Fort Street Public School Traffic and Transport Response to Submissions

SSD 10340

Prepared by Arup

24 June 2020

Figure 1 Phase 1 Student Drop-off and Pick-up

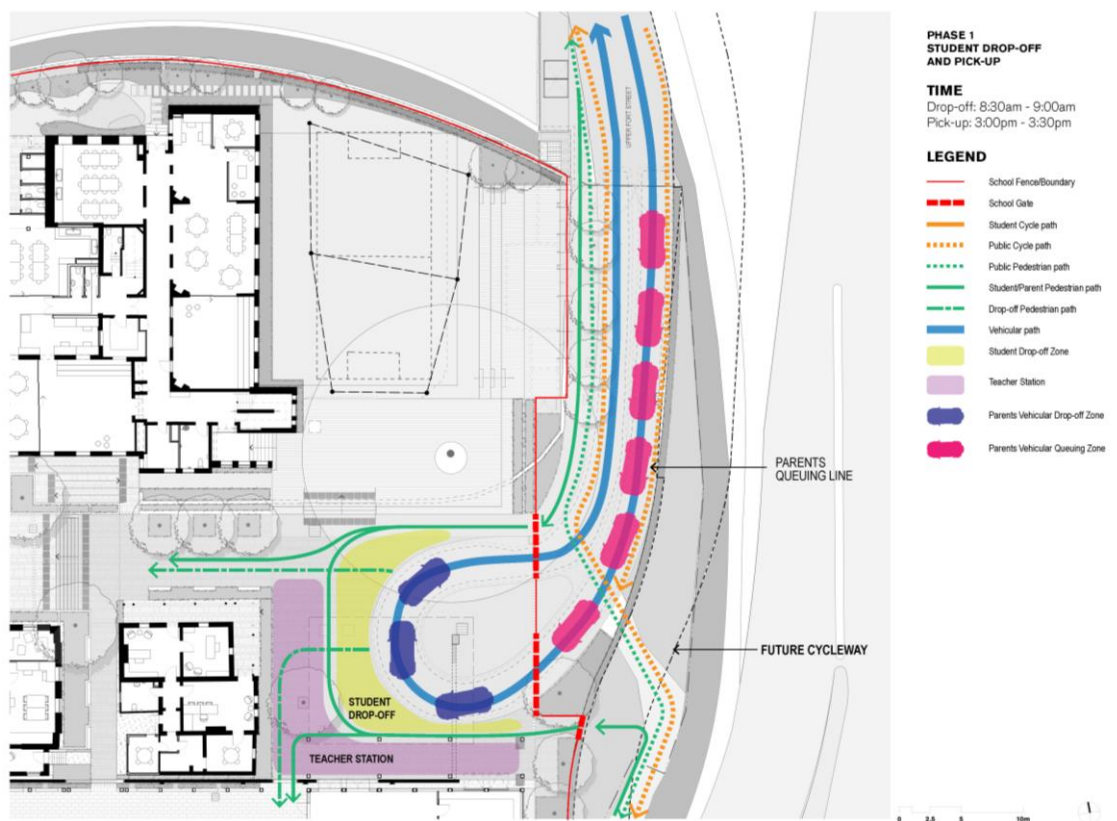
95	<p>Entrance to the school – concerns regarding the safe manoeuvring of vehicles, young children and parents at the pick-up/drop-off zone. Whilst road is being widened, there is only still one entry at the school. Proposed cul-de-sac U-turn arrangement will result in congestion, sight line issues for children using both side doors and rear boots. A linear drop-off/pick-up option is safer and more efficient.</p>	<p>The school is acknowledged to be in a constrained location; however, the arrangement of the cul-de-sac has been successful at other similarly constrained schools such as Lindfield Learning Village. This operation is shown in more detail in Section 3.2.</p>
96	<p>Concerns over queuing down the Argyle Place, management of crossings and intersections along that route, and broader impacts to surrounding streets. This issue also has to be considered in relation to emergency vehicles accessing FSPS during congestion.</p>	<p>The arrangement is designed to limit the likelihood of queuing in Argyle Place by allowing for 48 cars to queue within Upper Fort Street.</p> <p>Emergency vehicle access is possible using the passing points on Upper Fort Street, with lights and sirens operation where the cars stop moving and the vehicle drives onto the other side of the road.</p>

Figure 5 Phase 1 Waste Collection Swept Path Option 1

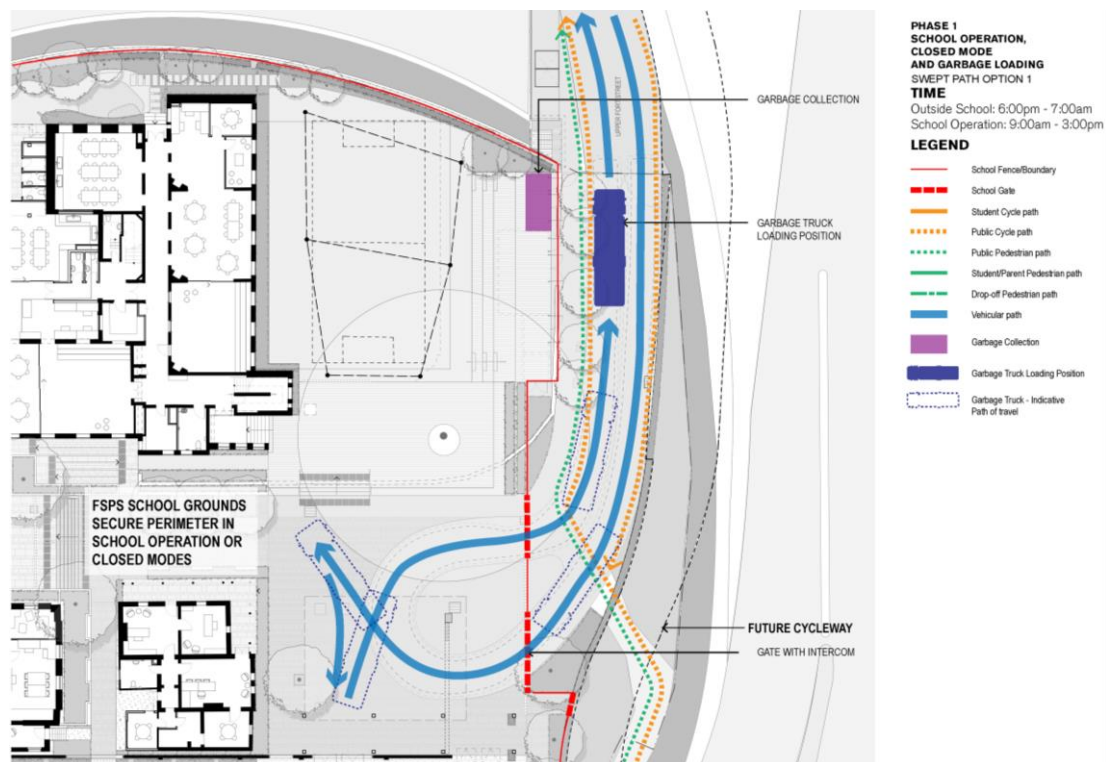
ID	Comment	Response
10	The Traffic Report, in one scenario, requires a garbage vehicle to make a U-turn within the school playground during a timeslot when school grounds are not being used for play activities, but conflicts with the Operations Statement which advises school grounds will be closed between 3:30pm and 8:30am. Clarification is required.	These activities will be allocated a time slot when the school grounds are not being used for school play activity. The grounds are able to be opened by a waste contractor outside of school operating times and the drop-off / pick-up times to facilitate this access.
11	The proposed vehicle turning circle within the school site and designated DO-PU zones within the school is not supported, due to potential conflict created between vehicles, students, and cyclists. Option that requires three-point turn in playground for garbage truck is not supported, entry and exit for waste collection is to be in a forward direction only. Will result in poor landscape and school play design. City recommends waste collection and DO-PU on Upper Fort St and not within school playground.	Council's concerns regarding DOPU arrangements and waste collection are outlined below. A road safety audit will be completed of this design and the design will respond to the audit items. In Section 3.4.2, entry and exit of the waste vehicle into the school is shown in a forward direction with some manoeuvring required within the school grounds. This will be managed to occur outside of school operating times and the drop-off / pick-up times, when students are not at play in this space. A second option for waste collection where the vehicle reverses into Upper Fort Street from the Observatory Road, is provided for flexibility of arrangements and to separate the truck movements from students.
